Page 14 of Staff Report

7. Conditions of Approval- City Engineer, Transportation Development:

Los Pastores SC – November 12, 2015 Hearing

This is agenda item #3, Project #1010550, 15EPC-40032.

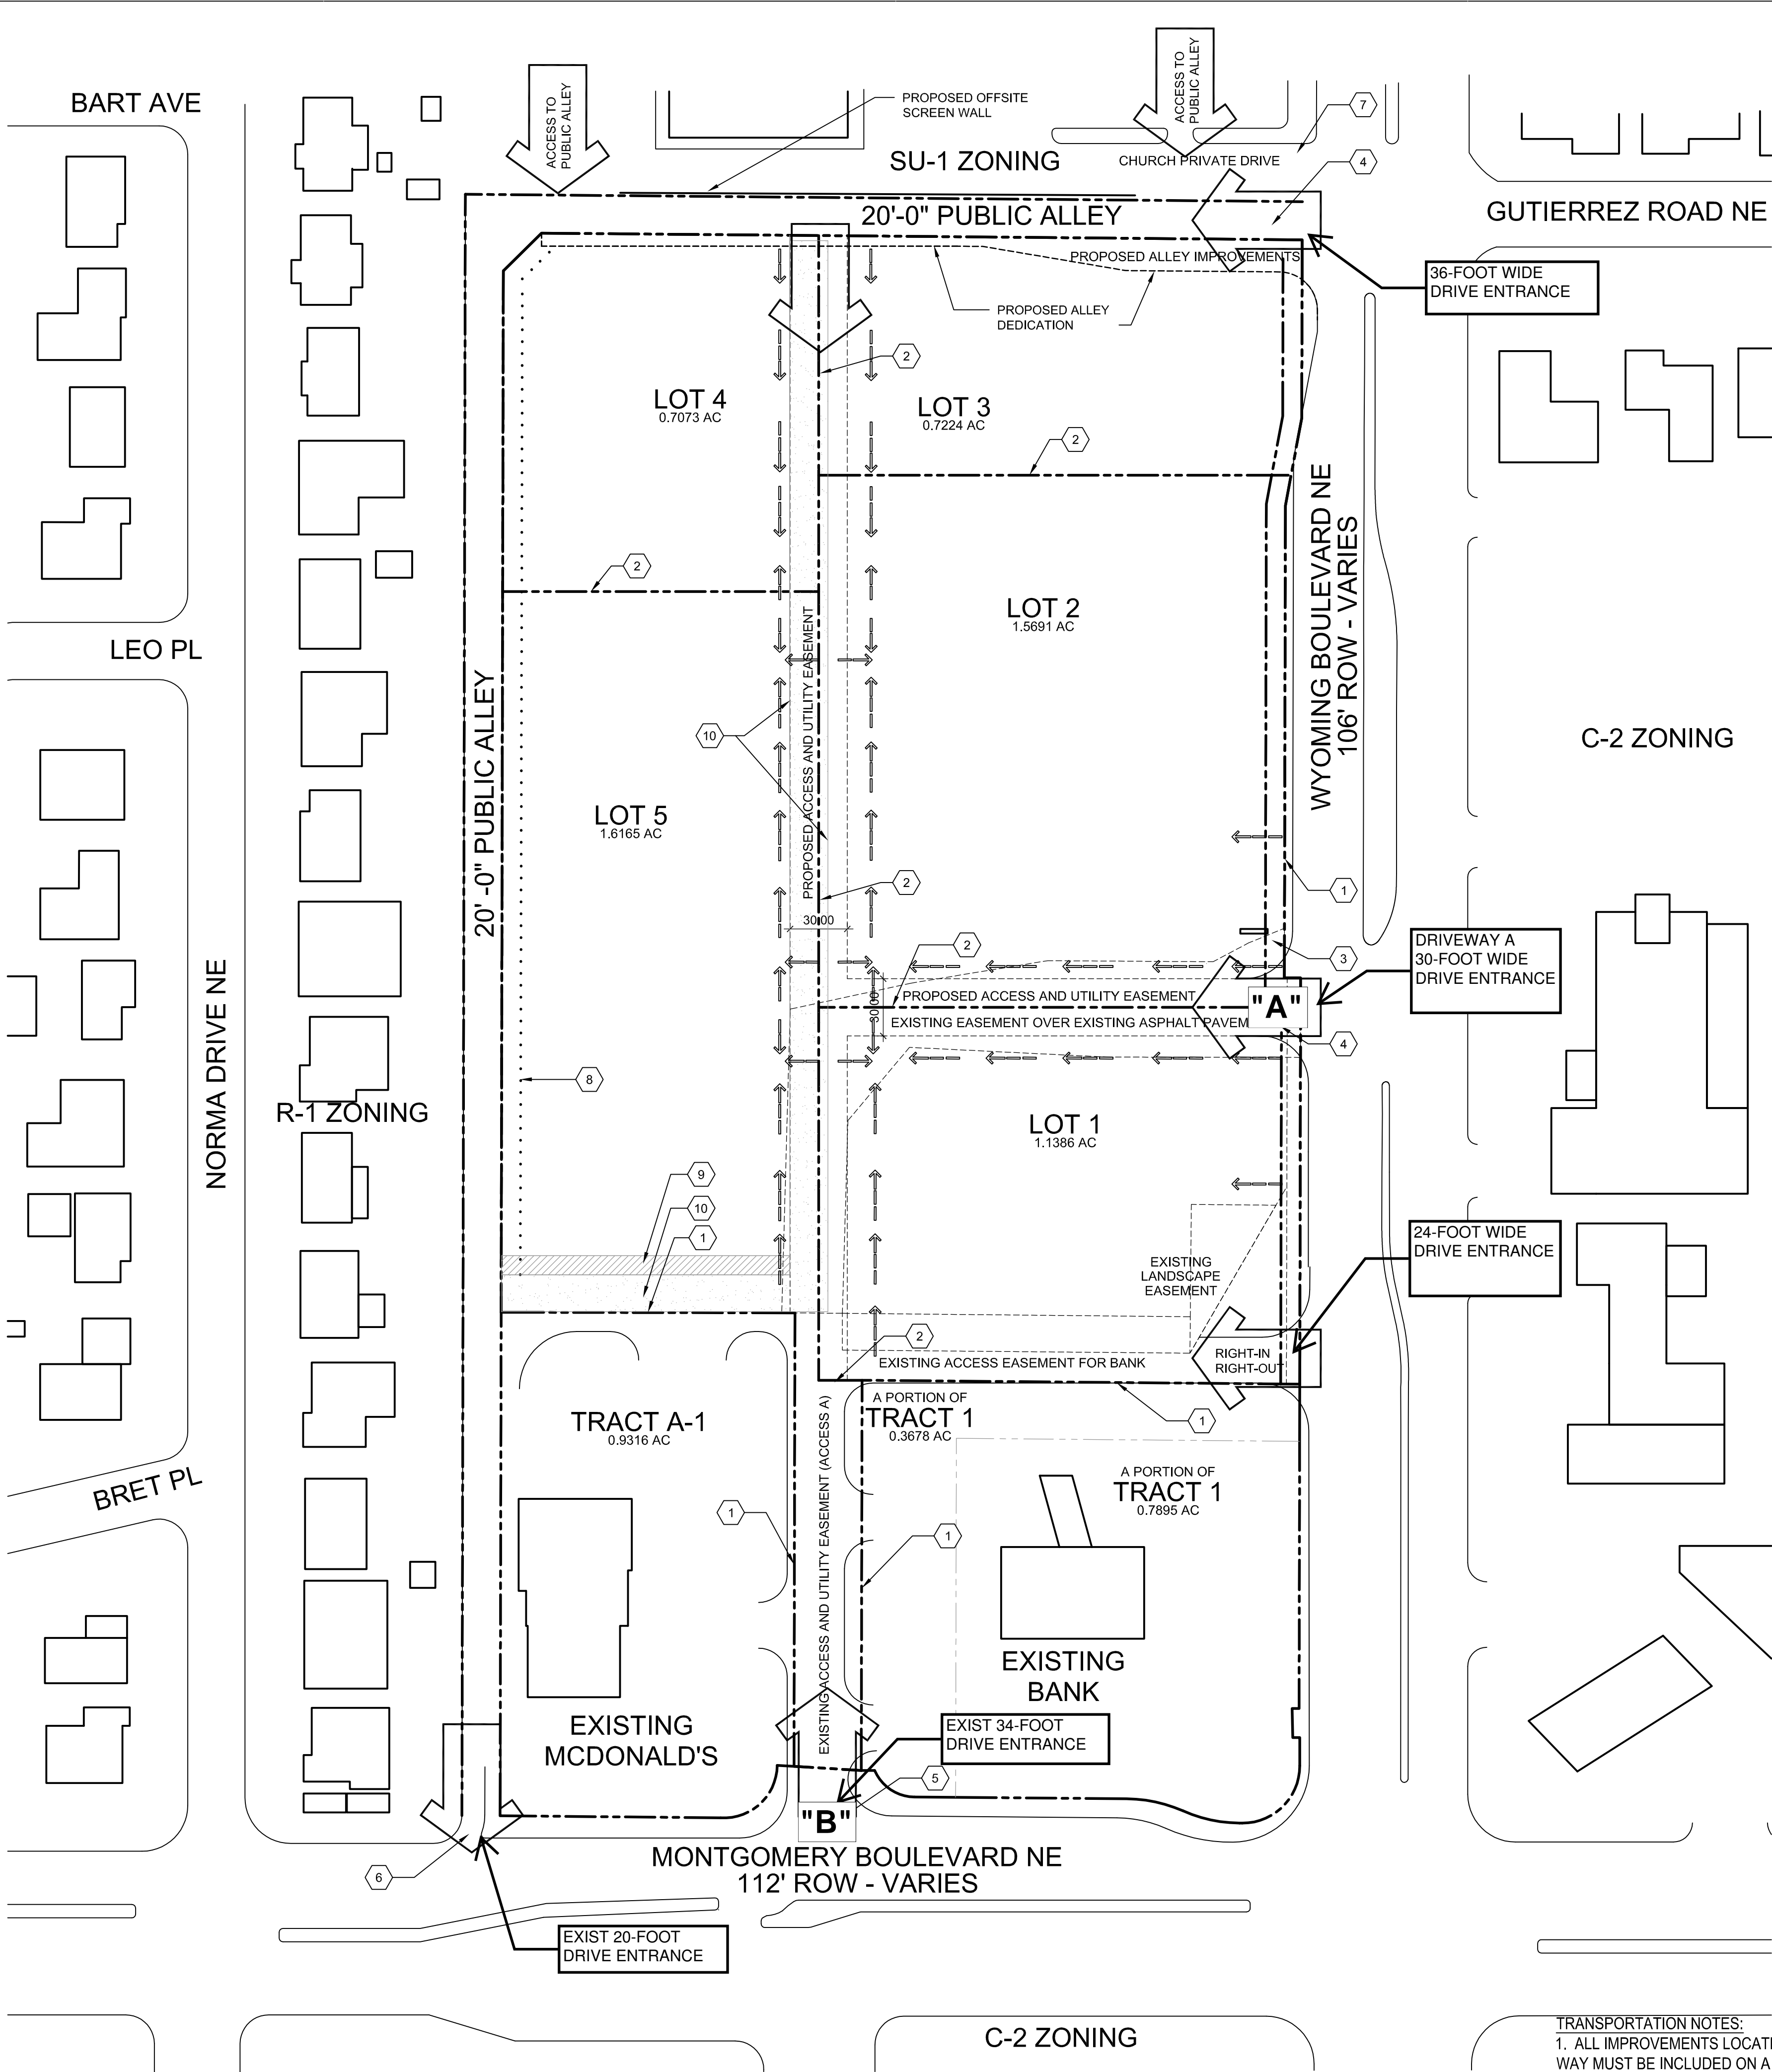
Keep • Developer must coordinate with the property located to the north regarding the entrance along the existing alley. A shared access to Wyoming must be built with this development. The Public Alleyway will be built allowing access to the property to the North in accordance with the Design Process Manual guidelines & City Policies. Not necessary but OK

- The access located on the south edge along Wyoming needs to be modified to be perpendicular to the roadway.

- Alley would have to be 24' for 2way

- dedicate additional alley?

- Alley stds, improved to site entrance
